# CITY OF ALBUQUERQUE

PLANNING DEPARTMENT – Development Review Services

February 5, 2015

**RE: Lot 32 P1 - Oxbow Bluff (File: G11D014D32)  
Grading and Drainage Plan, Engineer's Stamp Date 1-15-15**

ENGINEER'S SEAL  1/14/15 DAVID SOULE P.E. #14522	LOT 32-P1 OXBOW BLUFF SUBDIVISION	DRAWN BY JDG
	GRADING AND DRAINAGE PLAN	DATE 01-13-2015
 Rio Grande Engineering 1606 CENTRAL AVENUE SE SUITE 201 ALBUQUERQUE, NM 87106 (505) 872-0999	SHEET # 1 OF 1	JOB #

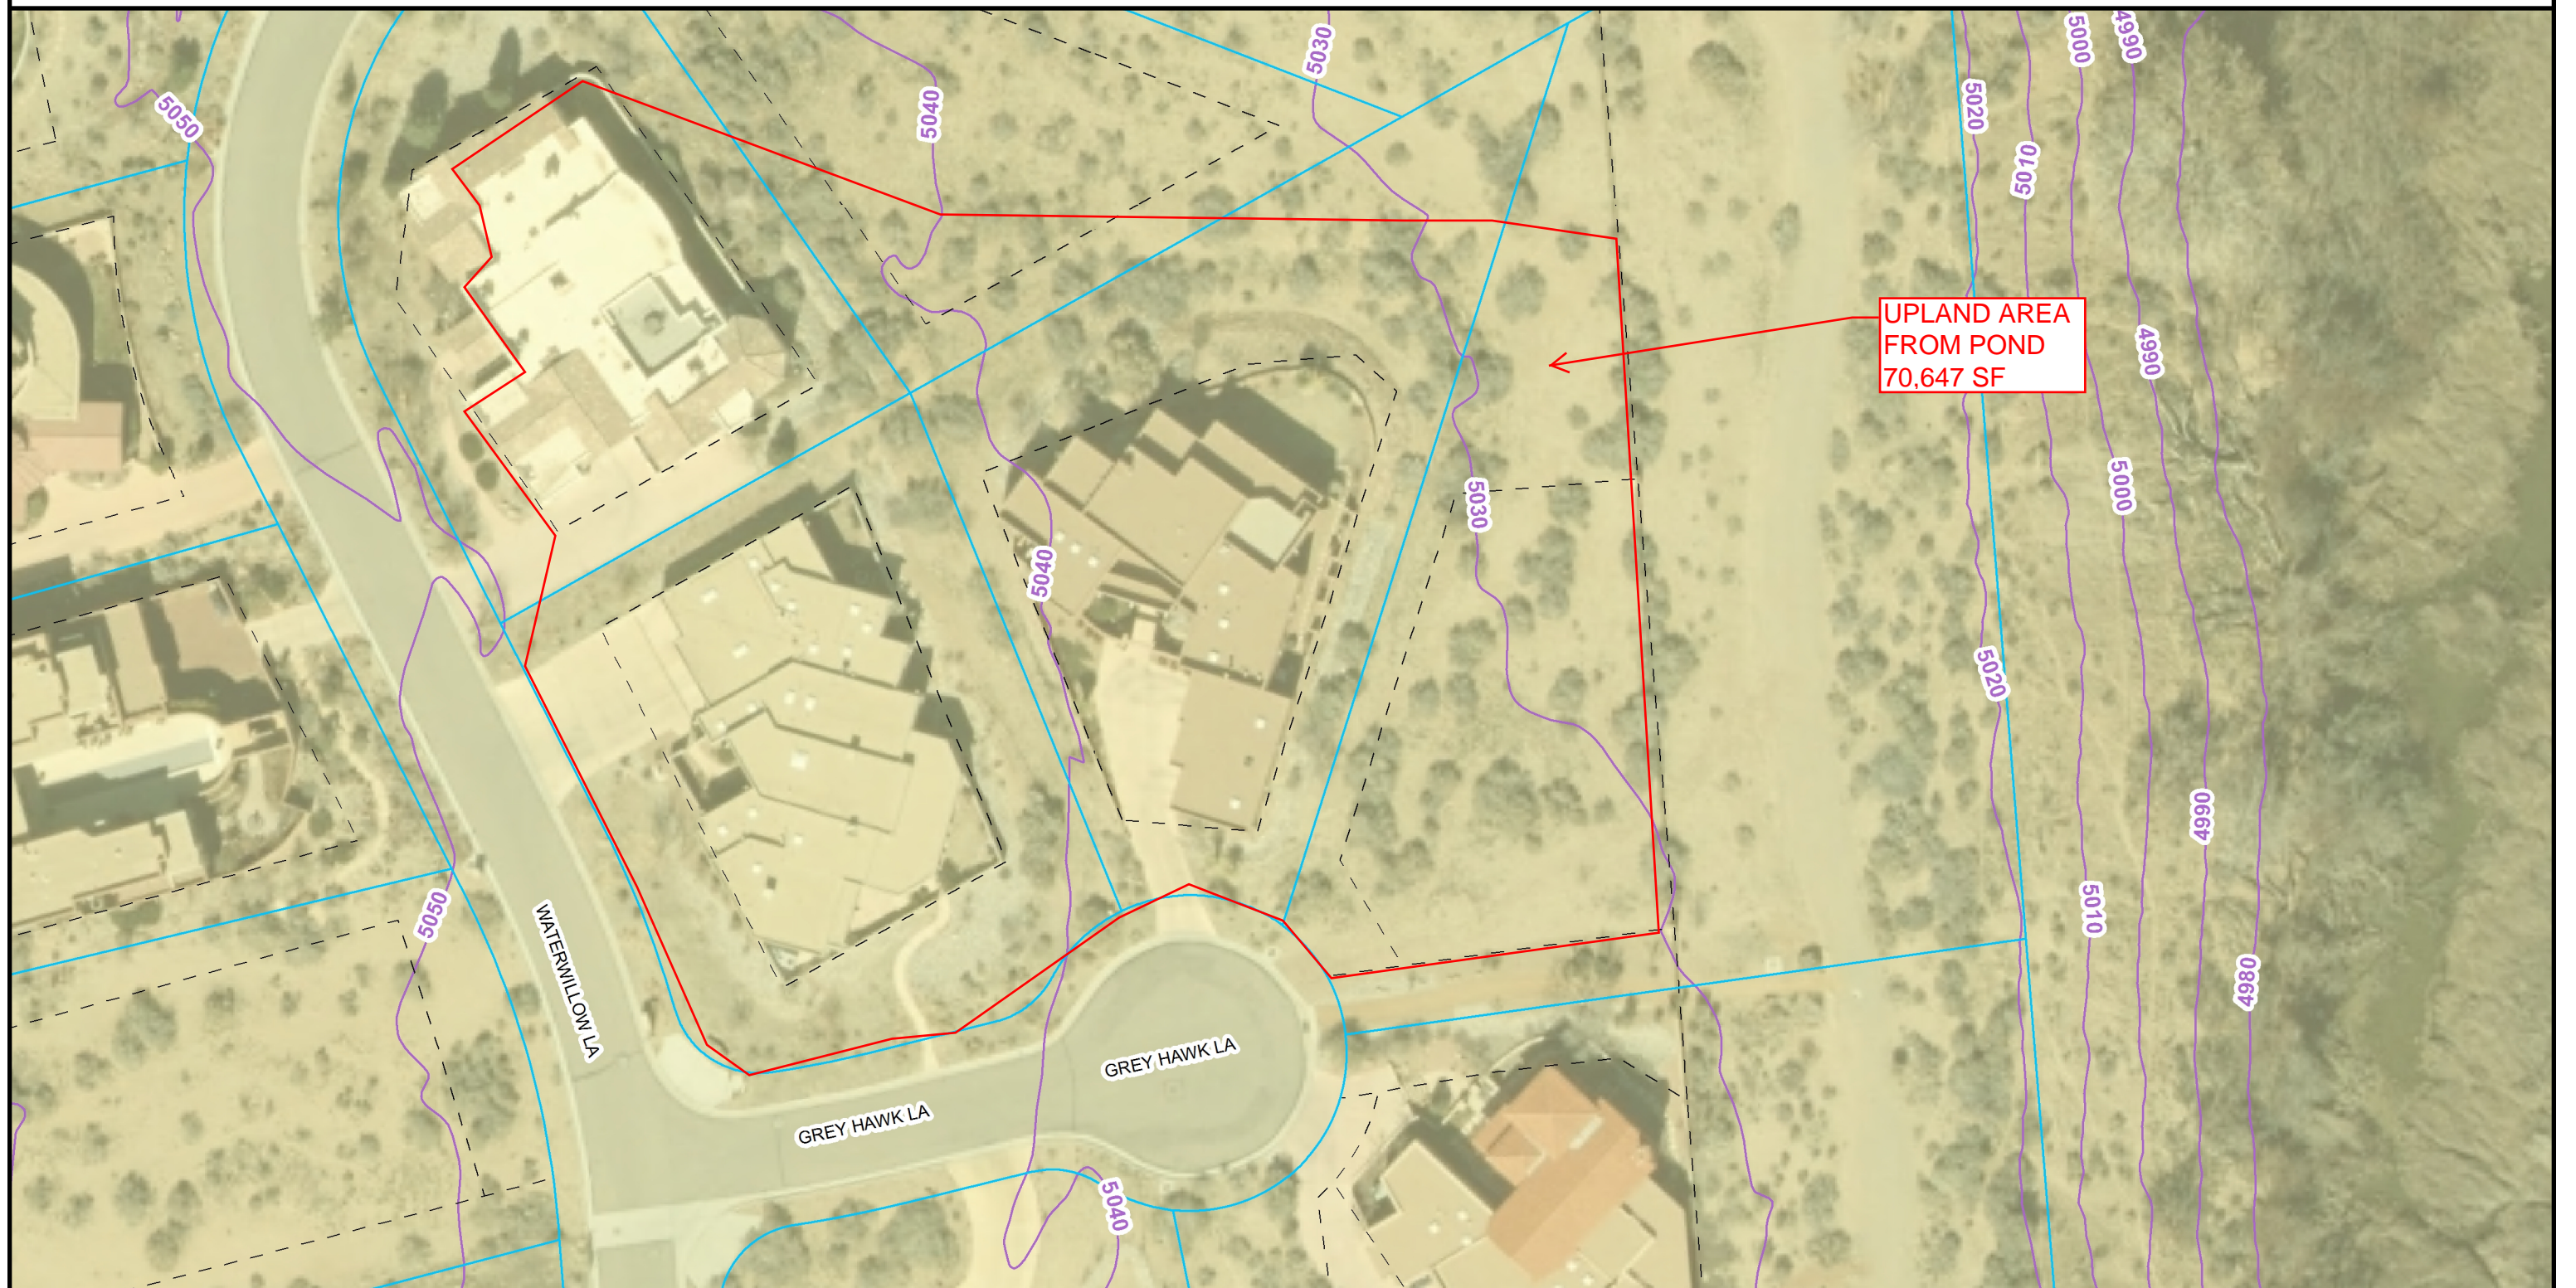
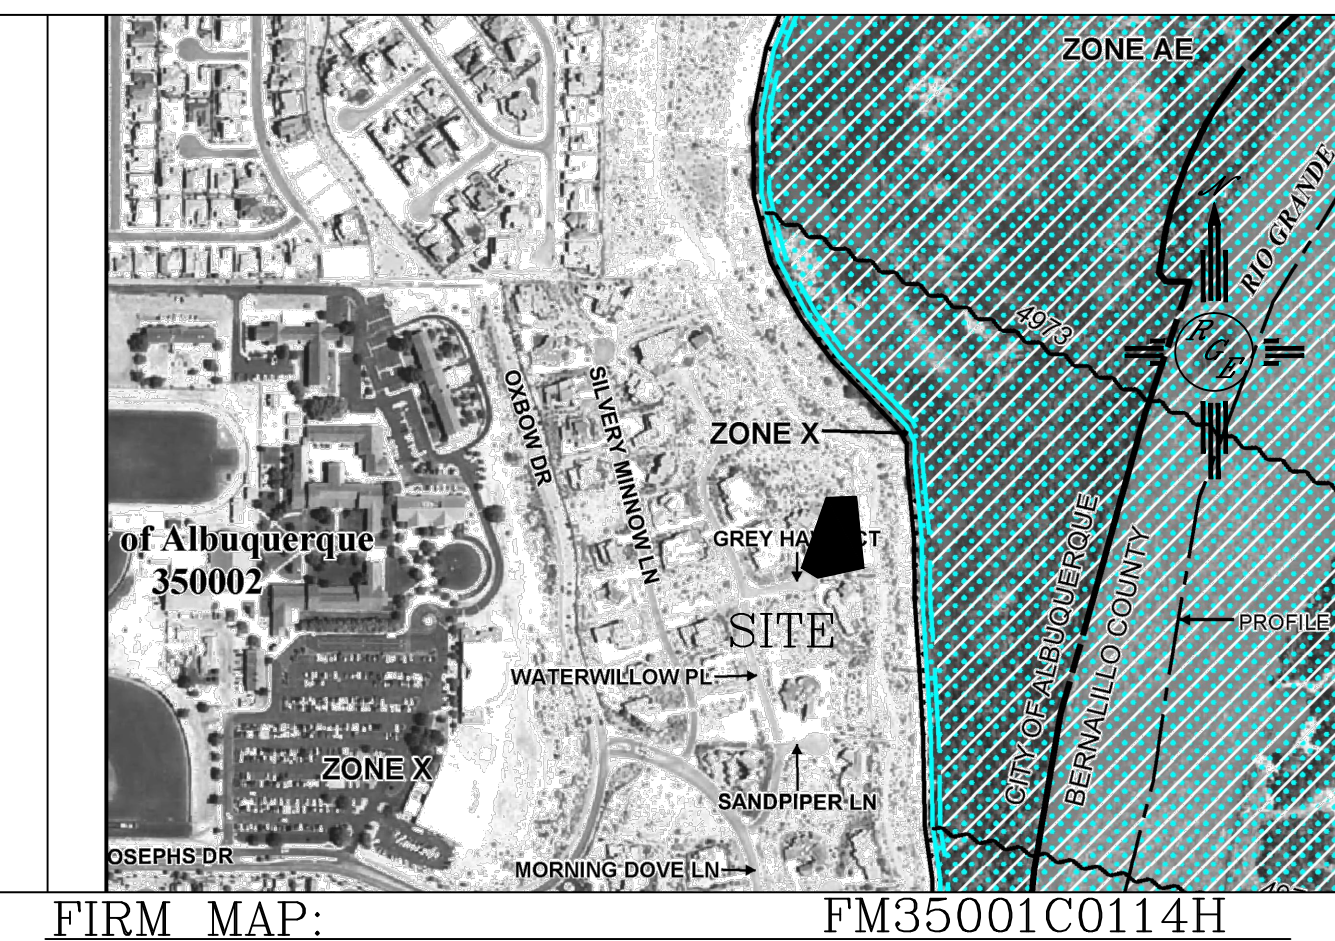
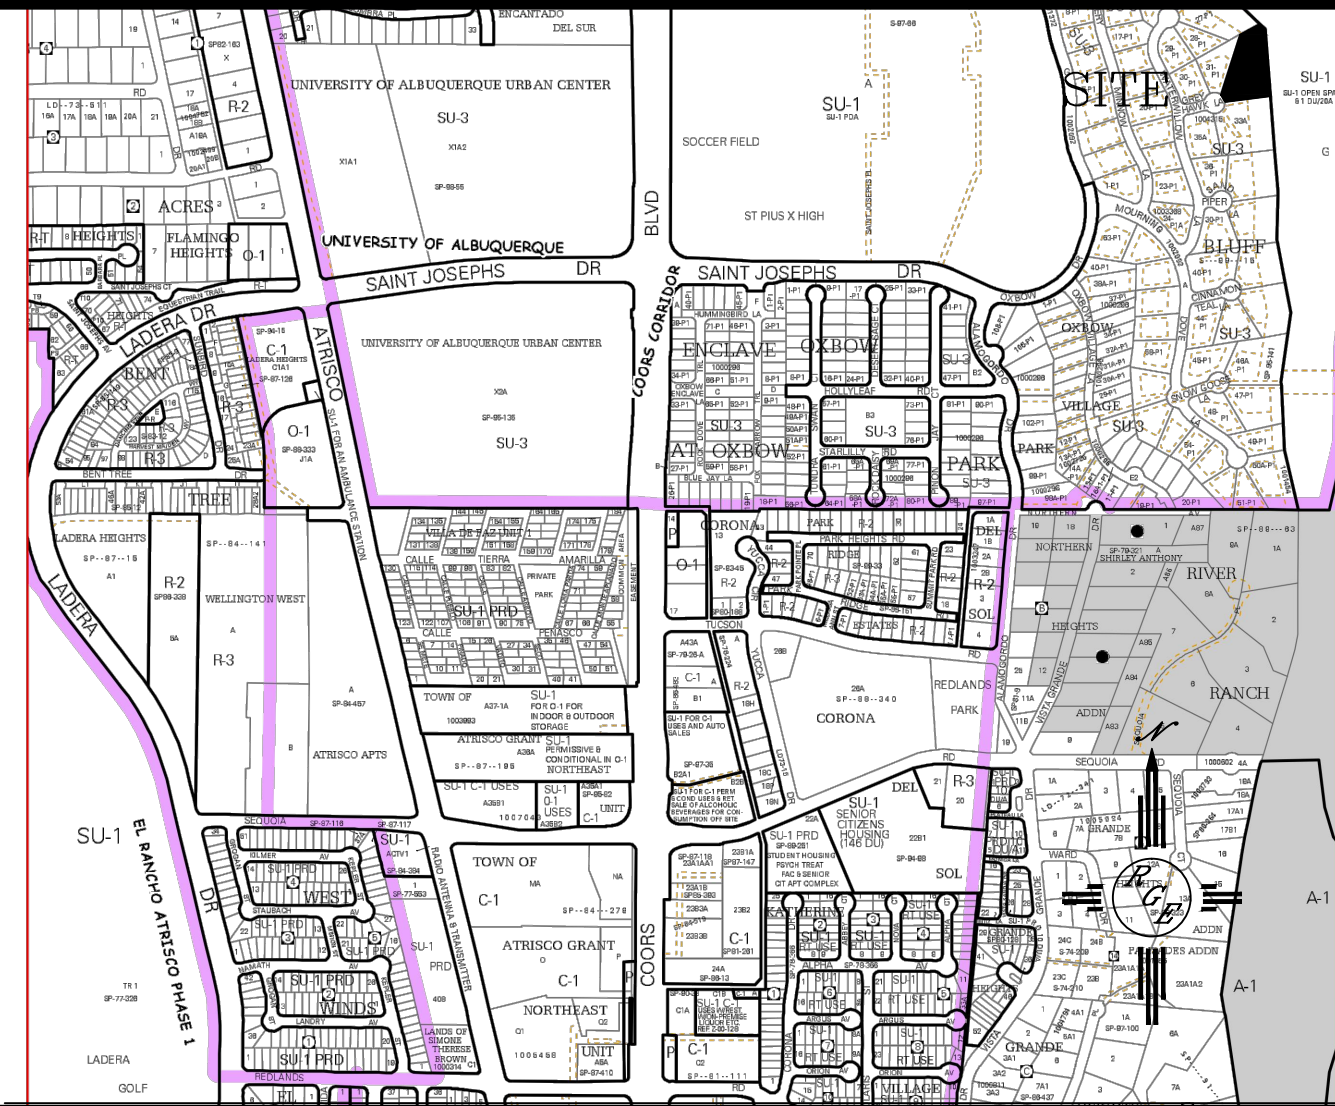
1. The Drainage is per the Oxbow Bluff Subdivision (Tract F) Drainage Report (Nov. 26, 1997) File G11D014D, Basin L.
2. Per the Master Drainage Report all proposed Grading and Drainage plans need to be reviewed and approved through the subdivision's architectural review committee prior to Hydrology approval being issued. Oxbow Bluff ACC has a contract with Bohannon-Houston to perform the reviews. Please submit the approval letter from BHI.
